From: Jonathan Best <Jonathan.Best@arun.gov.uk>
Sent: 06 October 2026 14:09
To: Planning.Responses <Planning.Responses@arun.gov.uk>
Cc: Kathryn Welch <Kathryn.Welch@arun.gov.uk>
Subject: LU/230/26/DOC

16 Swanbourne Road Littlehampton BN17 6HS.

I have reviewed the approval of details reserved by condition imposed under LU/98/26/PL relating to conditions 10-Biodiversity Enhancement Layout and 11-Statutory Biodiversity Net Gain Plan.

Drawing No	Revision
260053/ 03	A

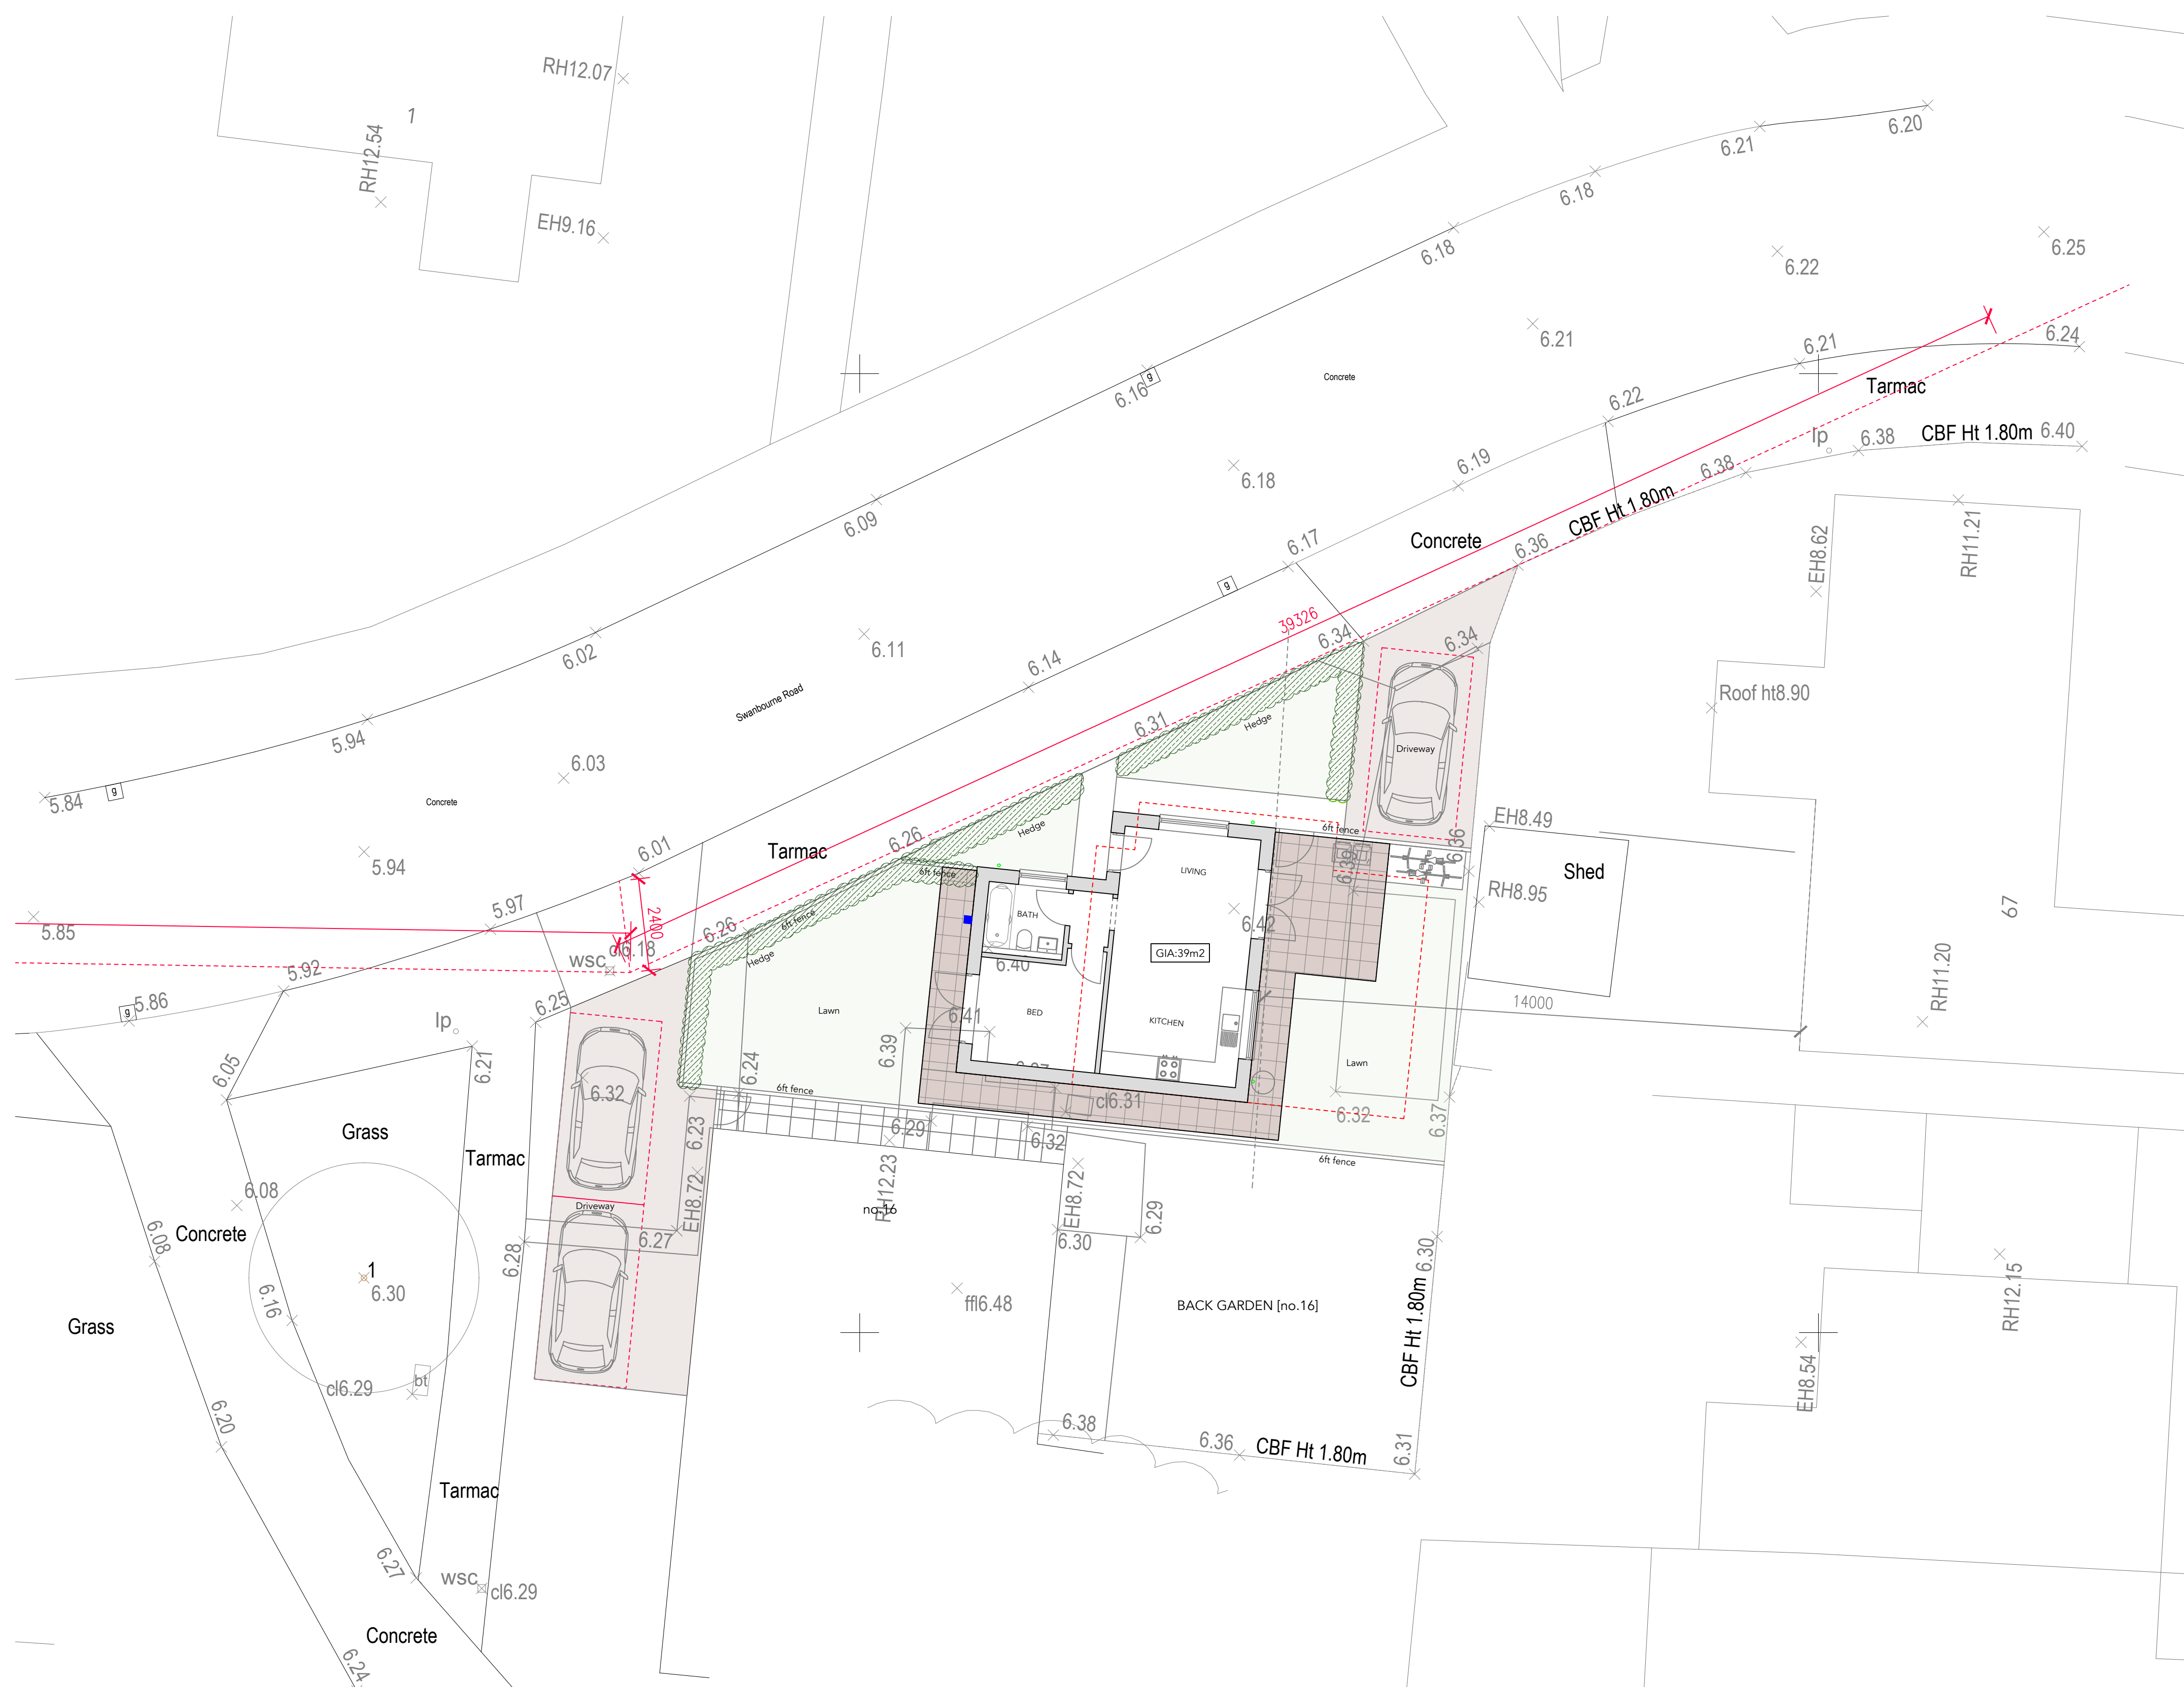
Condition 10-Biodiversity Enhancement Layout requires further details. The plan shows three ecological features on the key but only the swift brick on the plan. The integral swift brick should be changed to an integral bat brick. It is unlikely that a swift would use such a low brick. Also, the brick is on the western side and could also overheat.

Details of the species for the hedge have not been provided. Please provided details of the species being planted.
